**WELWYN HATFIELD COUNCIL – DEVELOPMENT CONTROL**  
**DELEGATED REPORT**

<b>APPLICATION No:</b>	<b>S6/2010/0747/FP</b>
------------------------	------------------------

This application seeks planning permission for an amendment to planning application S6/2008/1652/FP to change a first floor rear bedroom window to a pair of glazed doors with full height windows either side. A Juliet balcony is also proposed for the pair of proposed doors.

Project	93 The Ridgeway Cuffley
Drawing	Proposed Scheme Plans and Elevations with Juliet balcony
Date	July 08
Scale	1:100 A1 sheet
Drawn	mRn 8504/P/013a

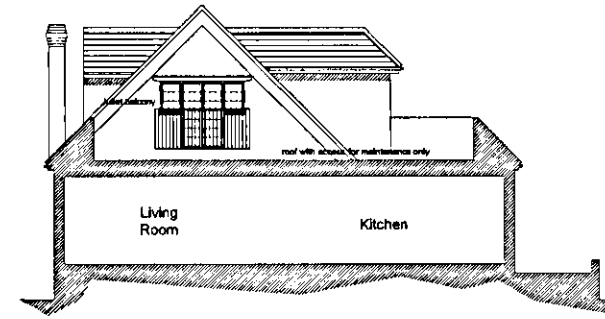
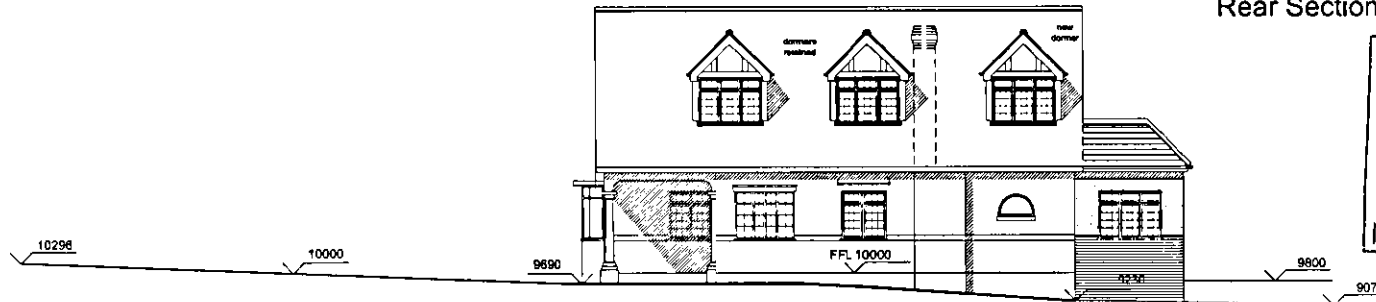
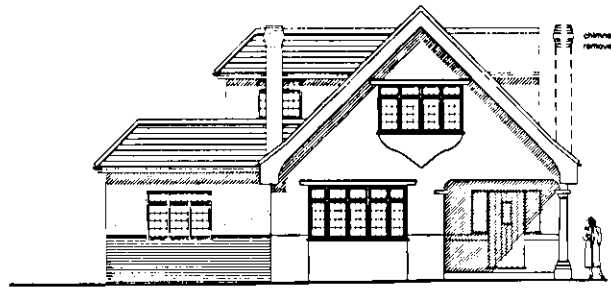
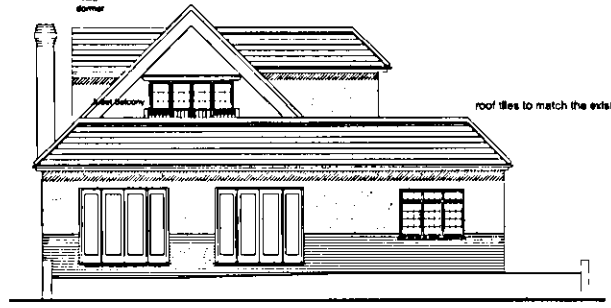
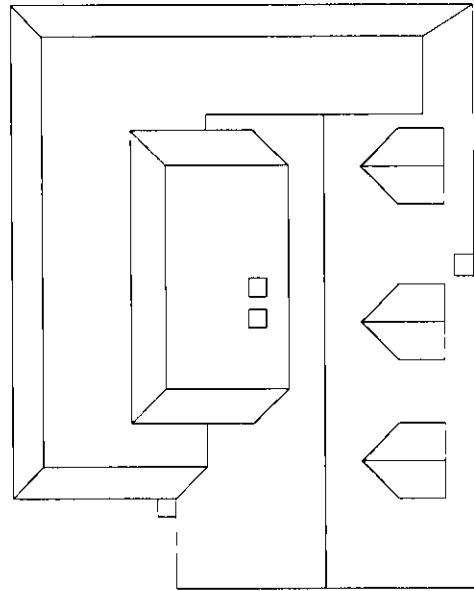
Northaw and Cuffley Parish Council comment : The PC have been unable to see the existing elevations to check how different the extension will be and have no drawing of the Juliet balcony at all. However, this seems to be in line with the other on 'The Ridgeway'

The adjoining neighbour has requested that any planning conditions imposed requires that it is constructed in one piece with no moving parts, which would prevent a gate that could be opened.

An amended drawing has been received which clearly shows all the elevation of the proposed balcony as requested.

Following a site visit, it was noted that the views achievable from the flat roof would give a clear and unobstructed view to the adjoining neighbours rear gardens and particularly to No.95.

This degree of overlooking, if used as an outside terrace area would result in a degree of overlooking which would not comply with the SDG.

In regards to the full height windows and doors, there would be no significant loss of privacy to the adjoining neighbours from views within the building.

It would be reasonable to support the proposal for the new doors and windows subject to the constraints that a Juliet balcony would restrict any access to the roof.

A planning condition ensuring that the railings of the balcony are fixed in place prior to first occupation of the master bedroom would be reasonable along with the retention of these unless the doors were removed and replaced with windows which are non opening below 1m from finished floor level.

1. C.2.1 3 Year standard time limit.
2. C.13.1: Development in accordance with approved plans/details : 8504/P/013a received and dated 28 May 2010.
3. The proposed Juliet Balcony railings as shown on approved drawing 8504/P/013a received and dated 28 May 2010 shall be installed prior to the first occupation of the master bedroom shown on this approved drawing. The design of these balcony railings shall be made of one piece which is securely bolted to the adjoining wall with no moving parts. This balcony railings shall remain in-situ thereafter. Furthermore, no access shall therefore be provided to the roof of the approved ground floor rear extension by way of any windows, doors or staircases and the roof of this extension hereby permitted shall not be used as a balcony or sitting out area.
